CITY OF ALBUQUERQUE

**Planning Department
Transportation Development Services Section**

Re: Certification Submittal for Final Building Certificate of Occupancy for
Iron Workers Local 495 - Training Shop, [M-16 / D041]
2524 Baylor Dr. SE
Architect's Stamp Dated 12/16/08

TRAFFIC CERTIFICATION
NEW BUILDING at IRON WORKERS LOCAL 495

TRAFFIC CIRCULATION LAYOUT

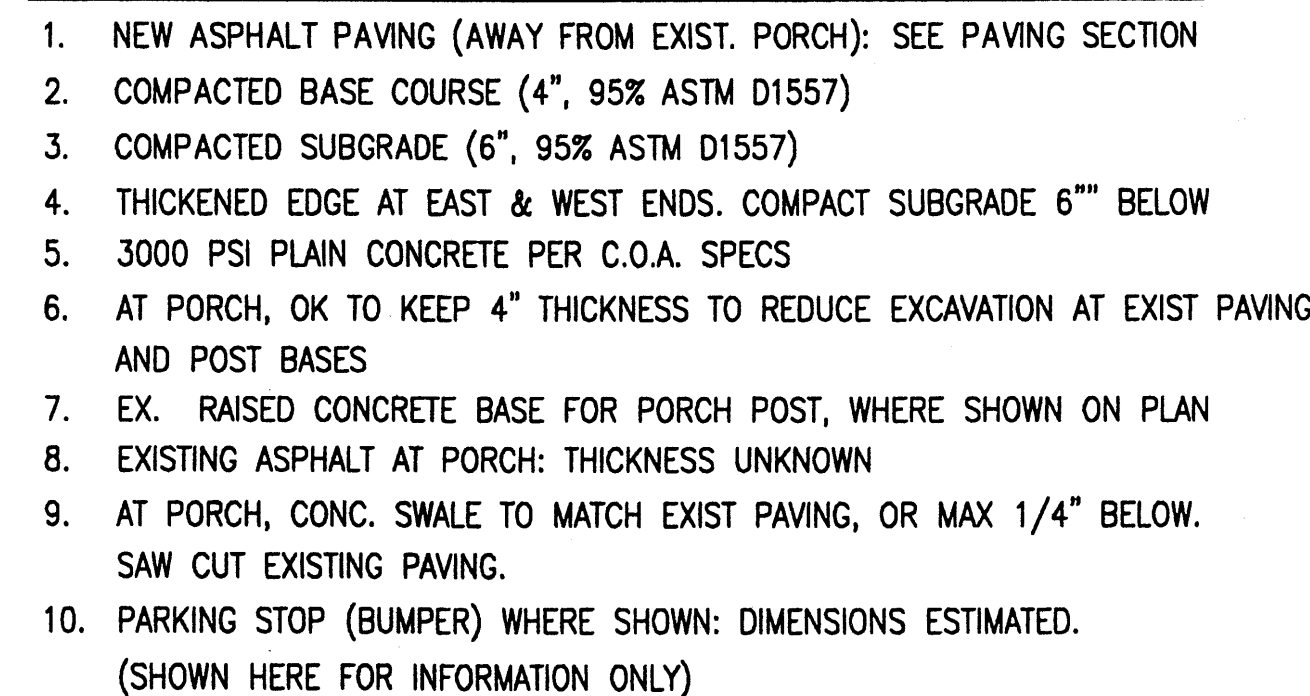
EXCEPTIONS AND QUALIFICATIONS: THE LOCATION OF PARKING SPACE No. 16 WAS CHANGED FROM ALONG THE SIDE OF THE NEW BUILDING AT THE BUILDING'S NW CORNER TO ALONG THE FRONT OF THE BUILDING AT THE SAME CORNER.
